Ref: 6/2022/0466/FULL
Date: 26/04/2022

HISTORIC BUILDINGS AND CONSERVATION ADVICE

RE: Northaw C Of E Primary School, Vineyards Road, Northaw, Hertfordshire EN6 4PB

The application is for: erection of a single storey part front extension.

Drawing Title:
 PROPOSED ELEVATIONS
 STAFF ROOM EXTENSION PROJECT

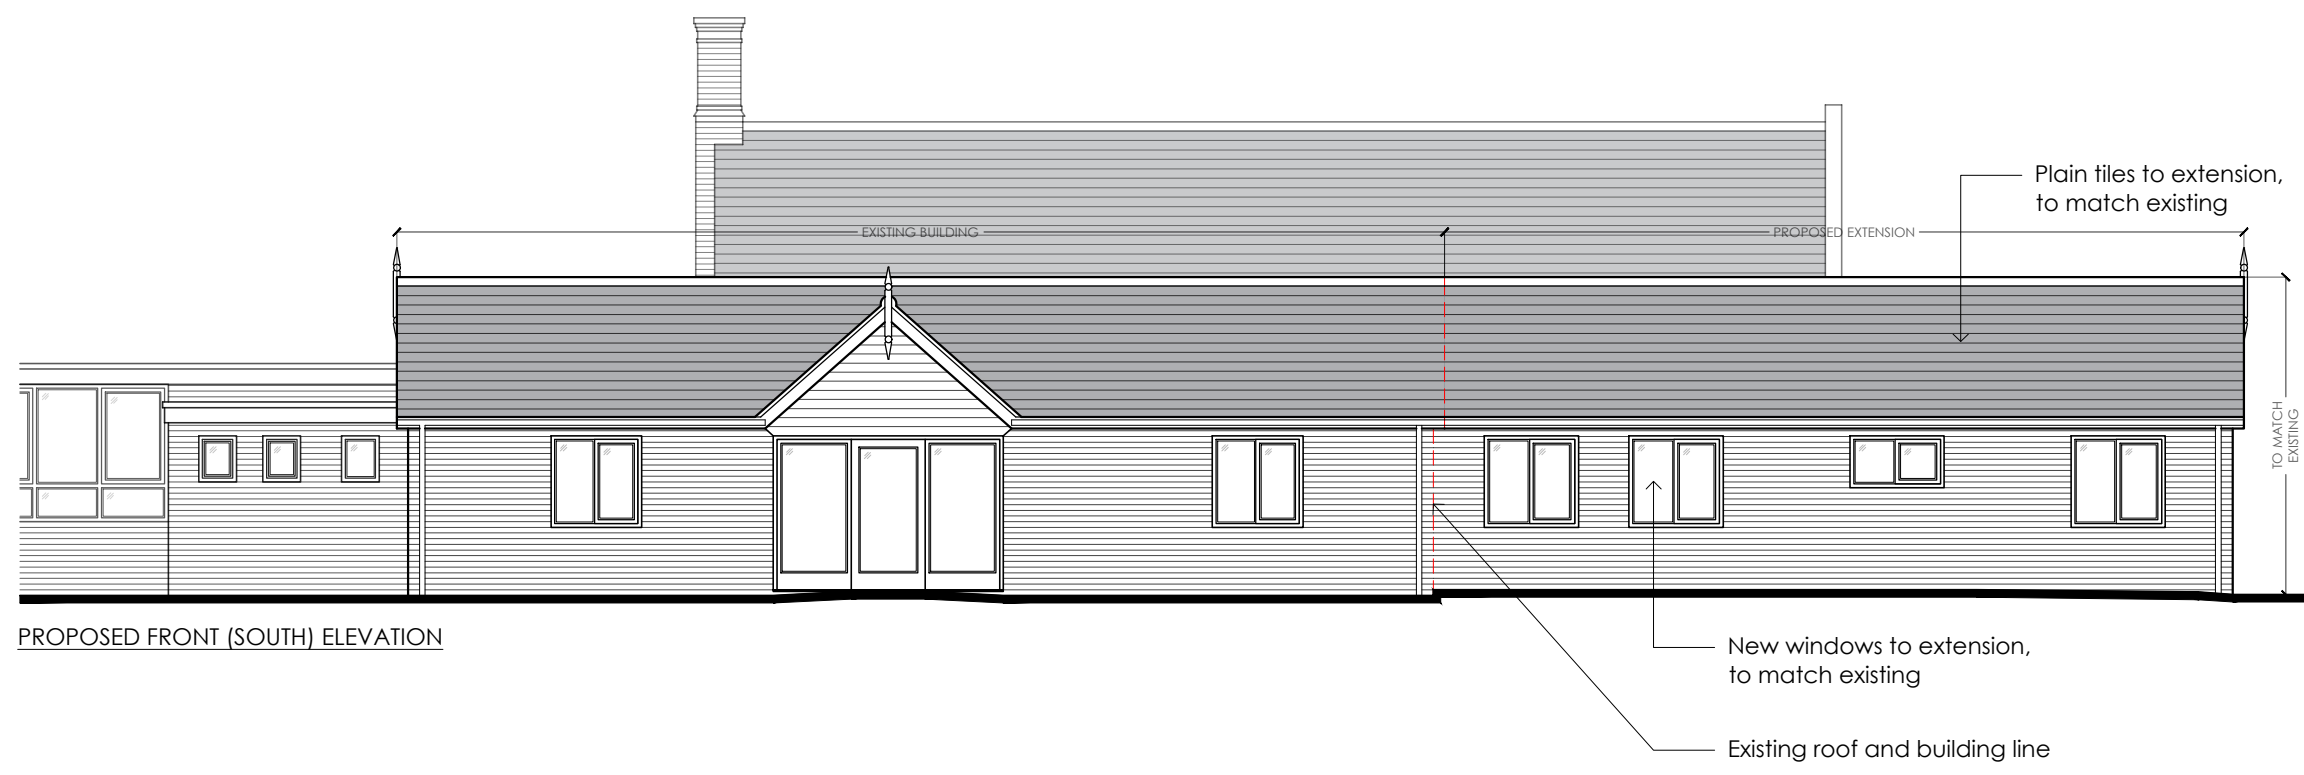
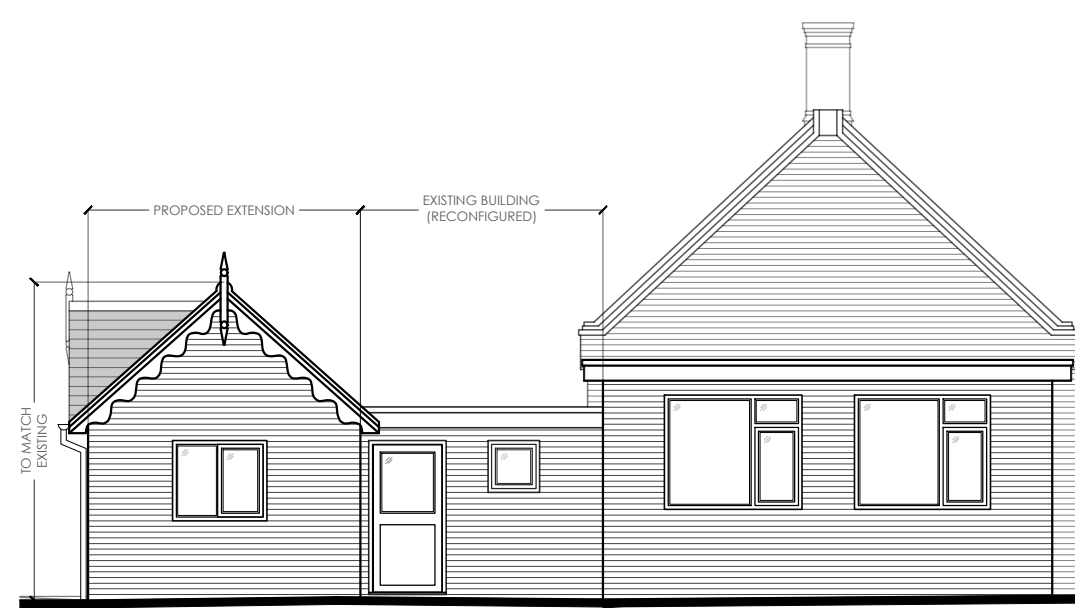
The proposed extension to the school would not harm the significance of either the listed buildings or the conservation area. The extension will have a traditional design that matches the current front elevation of the school and would be in keeping with the character and appearance of the area. In any case the small extension would be a minimal change that would not significantly alter views in and out of the conservation or the views of the listed buildings themselves. While there is a historic connection between the school and listed buildings, due to their locality, this connection would not be affected.
